Hi Emma,

I refer to the points identified below in the email from AP&S and provide the following comments:

Road Reserve Width

SCALE 1:50

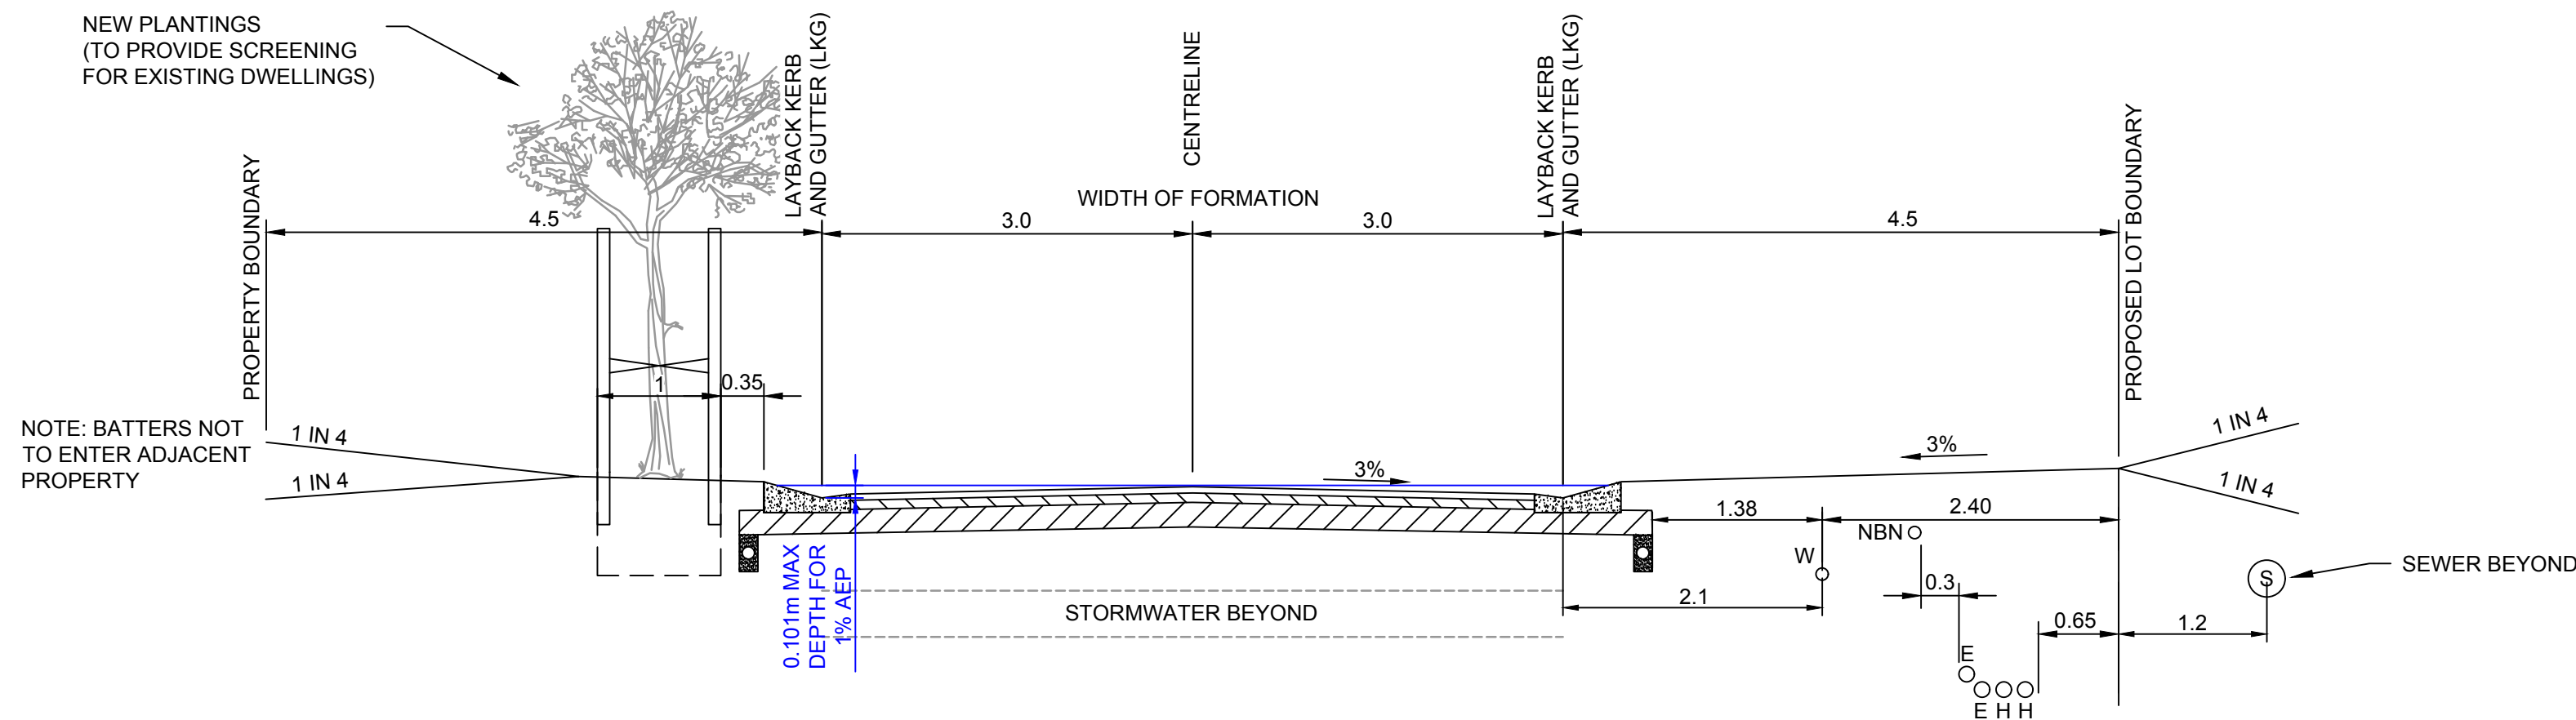
Council recognises the constraints of the layout and recommends the following road requirements.

- Road 1 (Entrance Road) CH0.00 to CH135.00,
 - 15m Road Reserve width as restricted by existing property boundary.
 - 7m wide carriageway (kerb invert to invert);
 - Upright Kerb – No property driveway required on this section of road
 - 2m width shared path on northern side

- Road 1 (Loop Road) CH135.00 - CH414.25 & CH135.00 - END
 - 16m Road Reserve width as per SDCP2014 Chapter G11.
 - 7m wide carriageway (kerb invert to invert);
 - Layback Kerb – for dwelling driveway;

- Road 1 (Section A) adjoining public reserve
 - **16m** Road Reserve width as per SDCP2014 Chapter G11.
 - **7m** wide carriageway (kerb invert to invert);
 - **Upright Kerb** – No property driveway required on this section of road;
 - **Open swale drain to** connect overland flow from drainage easement along the eastern side boundary of Lot 23 to drainage easement along eastern boundary of Lot 63,
 - **Multi-purpose:**
 1. for stormwater drainage management (to minimise overland run-off on road from northern drainage easement to Road 1 then discharge back to southern easement) and
 2. restrict future driveway access to existing dwellings on eastern side of subdivision

- Condition C9. 1) c. The entrance road shall have a 15m road reserve width with a 7m wide carriageway (kerb invert to invert) with upright kerb. The loop road shall have a 16m road reserve width with a 7m wide carriageway (kerb invert to invert) with layback kerb. Upright kerb is to be used on the section of road adjoining the public reserve. *(the remainder of C9.1c) to continue as per draft)*
- New condition C12 d) An open swale drain is to be constructed within the 2m wide public reserve to connect the overland flow from the drainage easement along the eastern side boundary of Lot 23 to the drainage easement along the eastern boundary of Lot 63
